Our ref : 9157/KS/001

**Proposed residential development – Land at Springfield Drive/Vancouver Drive, (rear of Ingsfield Crescent), Bolton on Dearne – Planning reference 2015/1464**

I write with reference to the comments made on 27 January 2016 by the Council's Highways Development Control Officer in connection with the above application.

SITE PLAN
scale 1:500

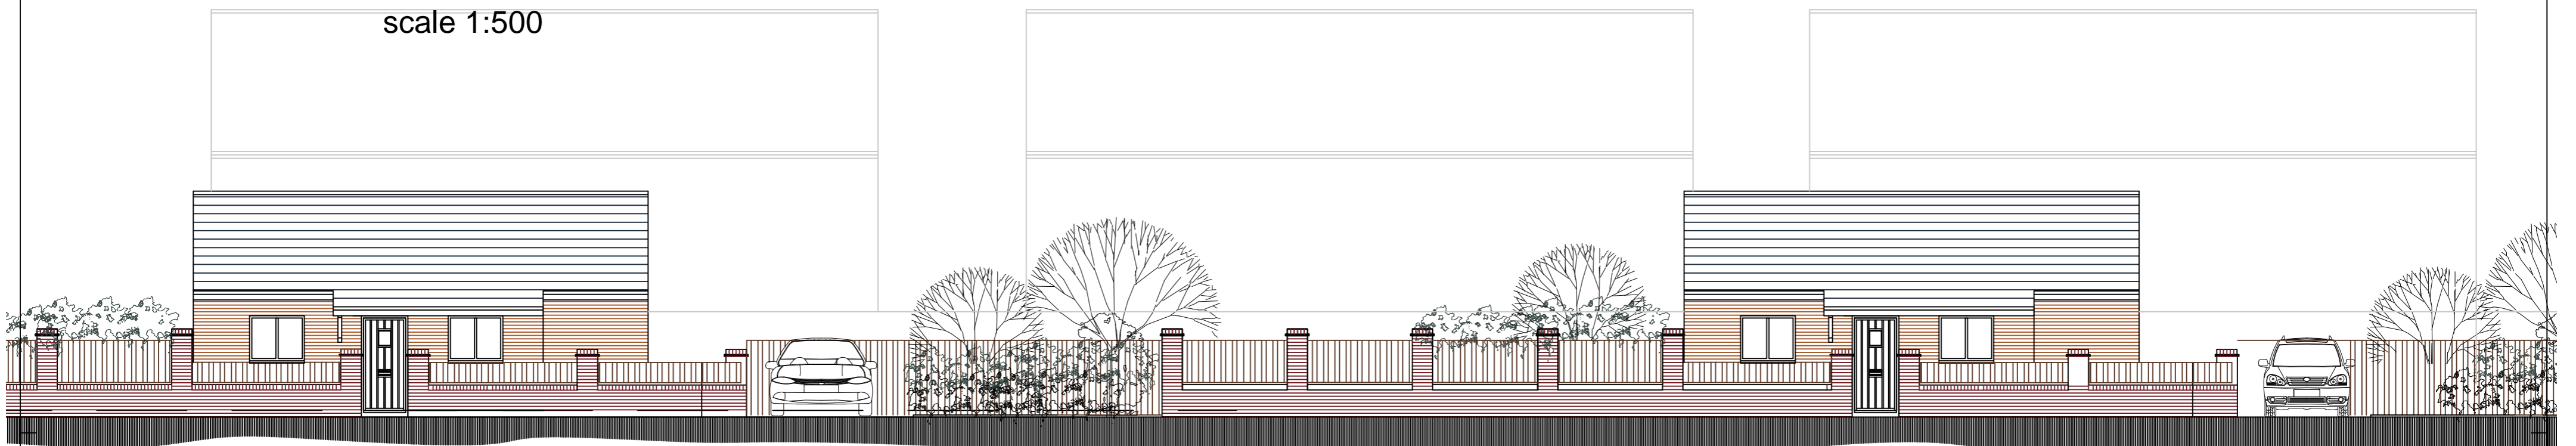
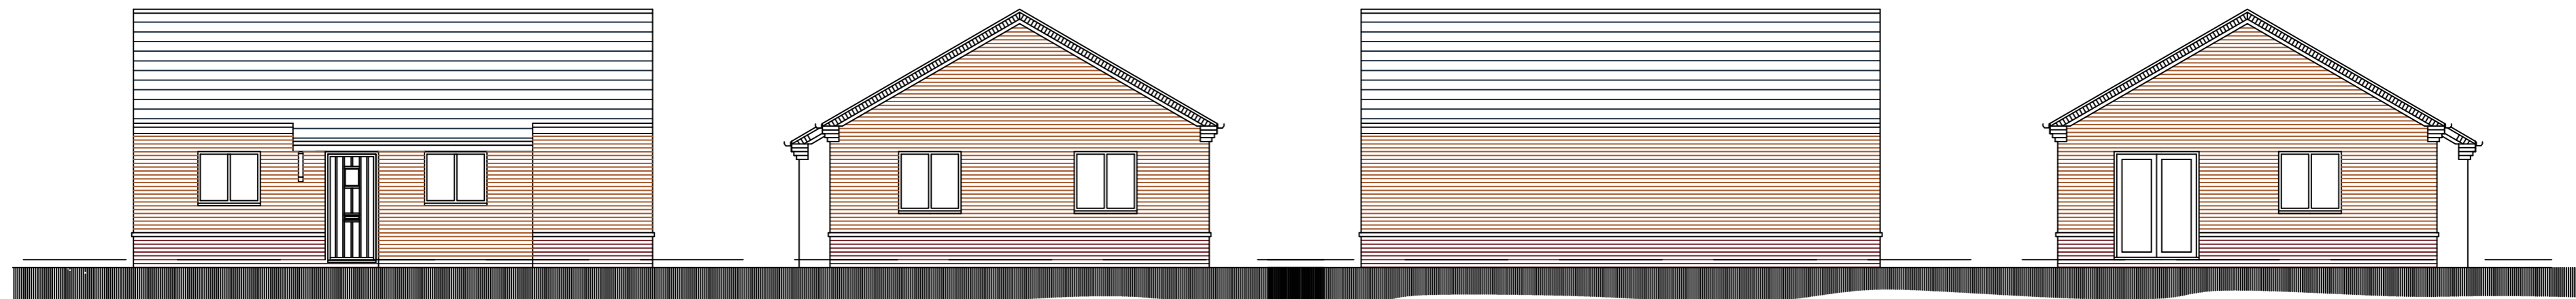
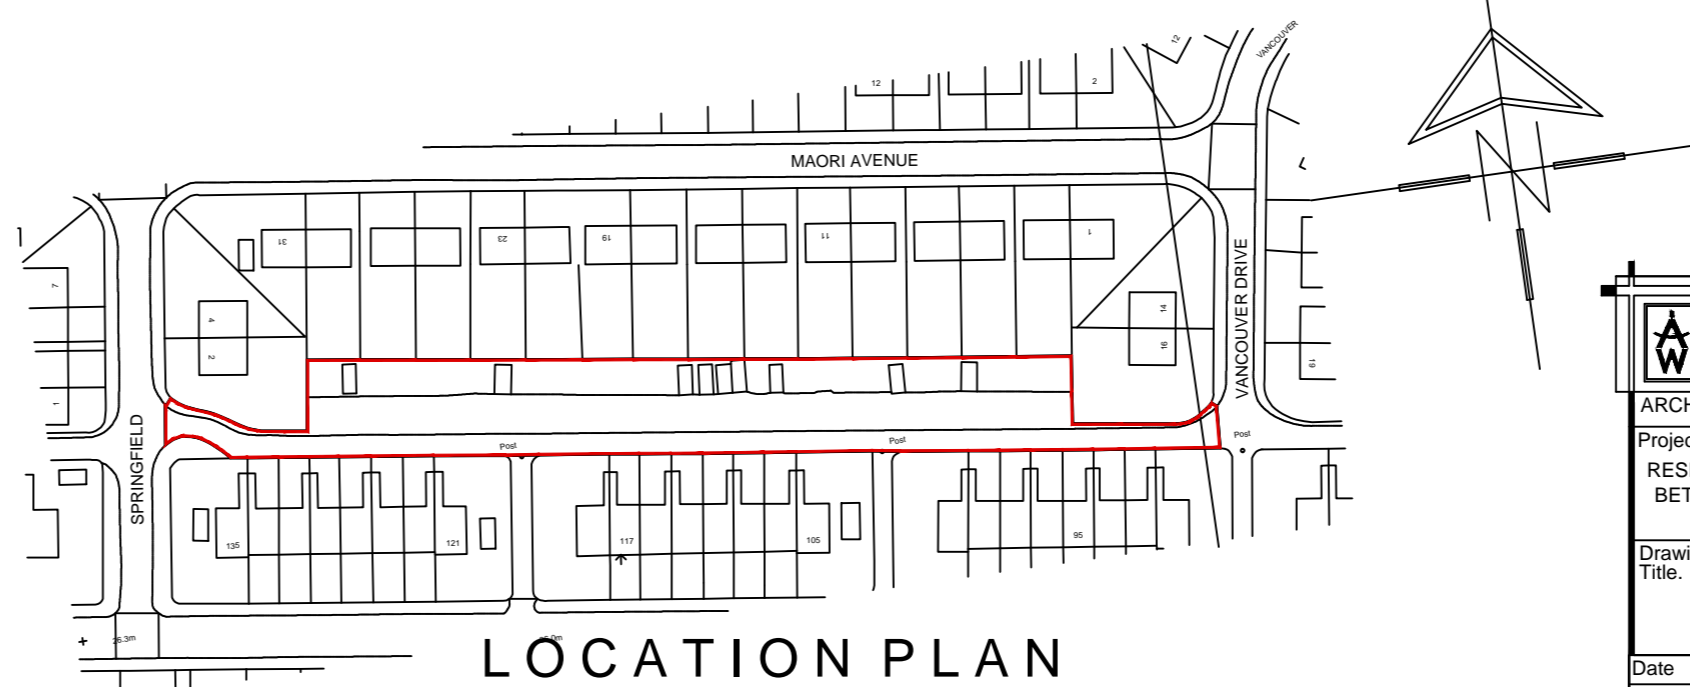
**1. Footway provision and Carriageway Widths**

## **2. Sight Lines at Proposed Driveways**

## **3. Visibility Splays at Junctions to Springfield Drive and Vancouver Drive.**

Notwithstanding the above I have, however, discussed the possibility of providing some improvements to the available width along the access road as part of the development with my client and attached is White Agus Partnership Drawing 15-103-01 Rev B which details widening to the development site frontage to provide a 4.8 metre wide carriageway which is sufficient to allow two cars to pass, and a car and a service vehicle to pass.

As can be seen from the attached drawing, the plot positions have also been amended from the original layout to provide improved visibility from the proposed driveways. The edges of the proposed driveways are now also shown splayed to increase driver and pedestrian intervisibility, with standard 45 degree splays at 2.4m.
